From: Michael Eastham <Michael.Eastham@arun.gov.uk>
Sent: 29 October 2020 16:08
To: Planning.Responses <Planning.Responses@arun.gov.uk>
Subject: FW: *EXTERNAL: FW: A/157/20/DOC Land South of Water Lane, Angmering.

Please upload onto Ocella the following email which is a further consultation response from the **Local Highway Authority** to discharge of condition application **A/157/20/DOC** relating to Land South of Water Lane, Angmering.

Please find attached a copy of the revised **Construction Management Plan** for discharge of condition application **A/157/20/DOC**.

Appendix C – Routing Plan

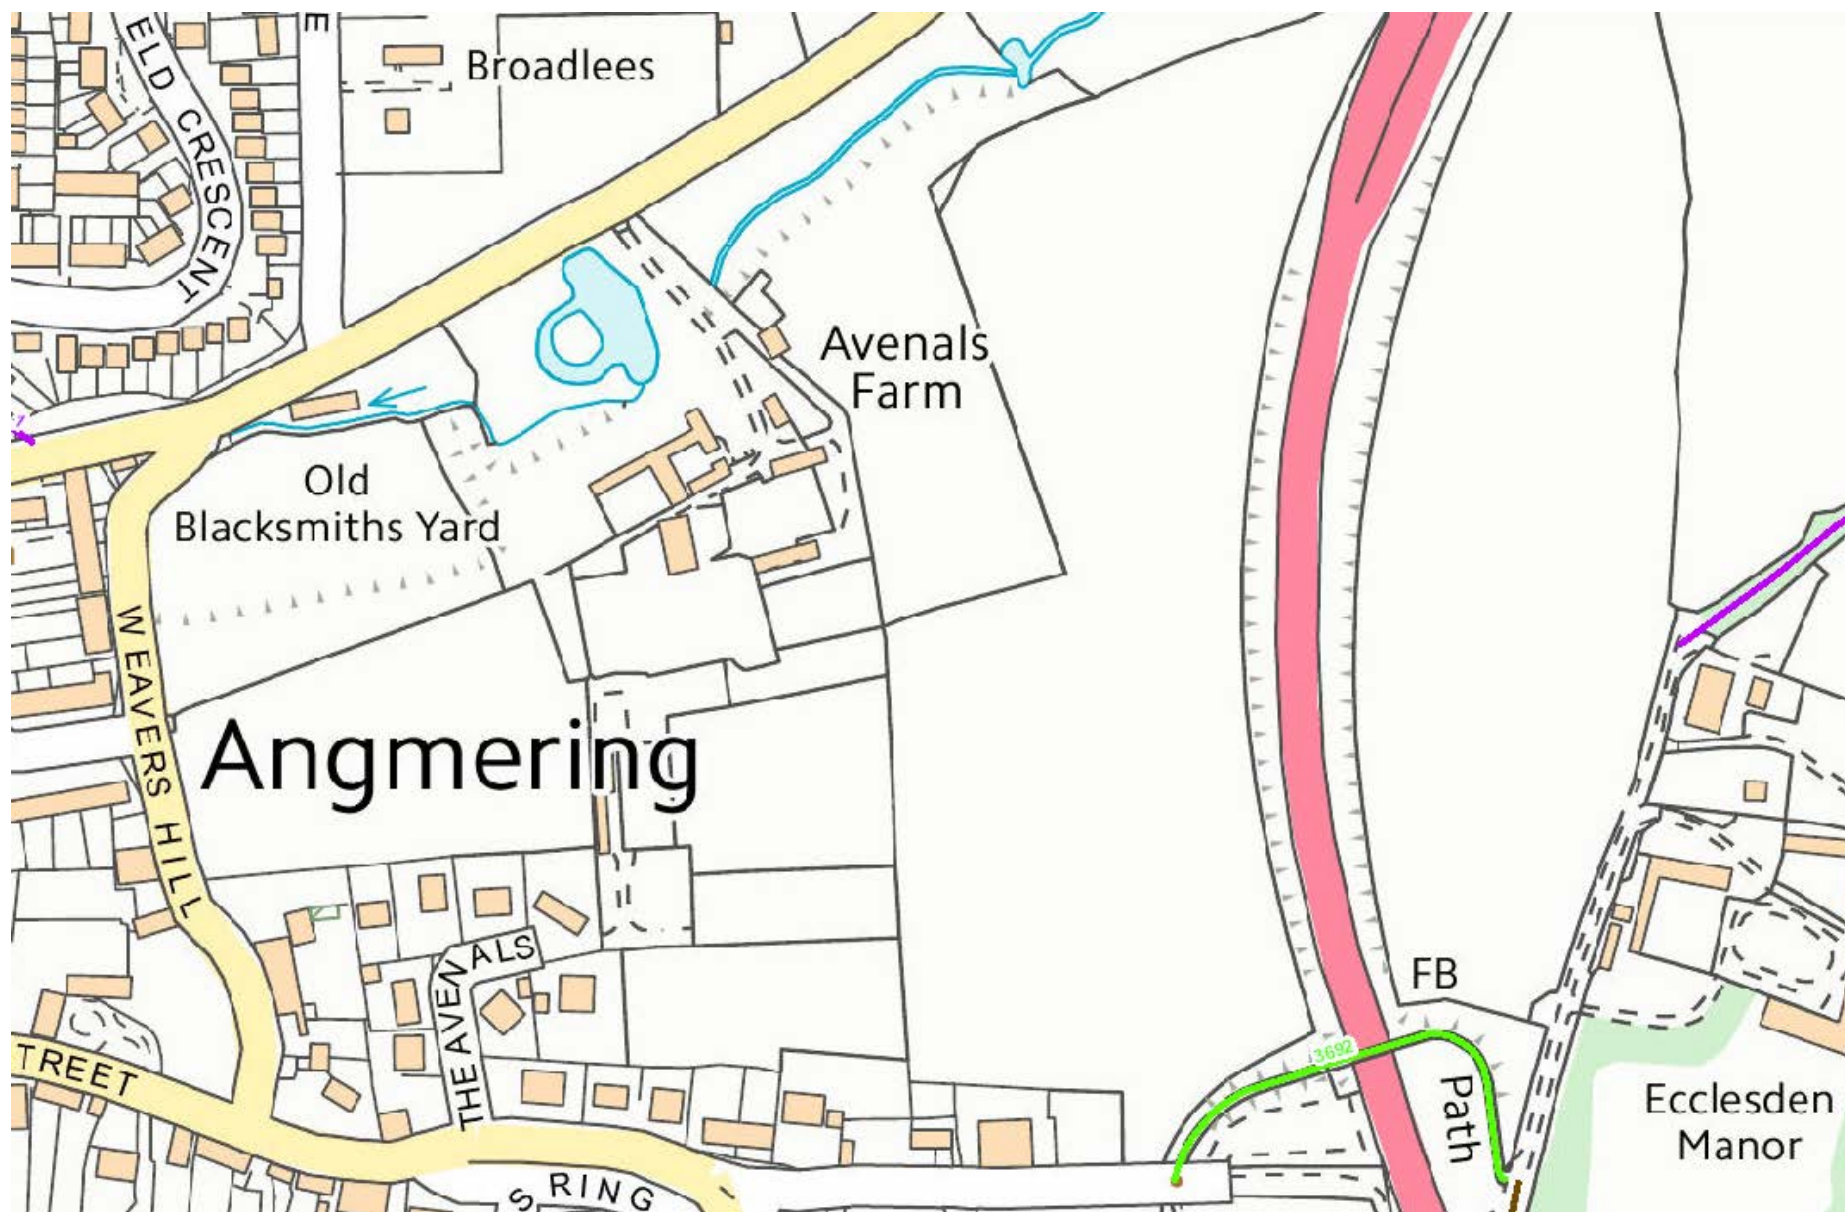
The revised CMP does include additional information regarding routing. With particular reference to the interim construction access routing as shown in appendix C, this is showing traffic making use of roads within Angmering village that are subject to legally enforceable width restrictions. Weavers Hill, in particular, would be wholly unsuitable for HGV access. This would need to be revisited.
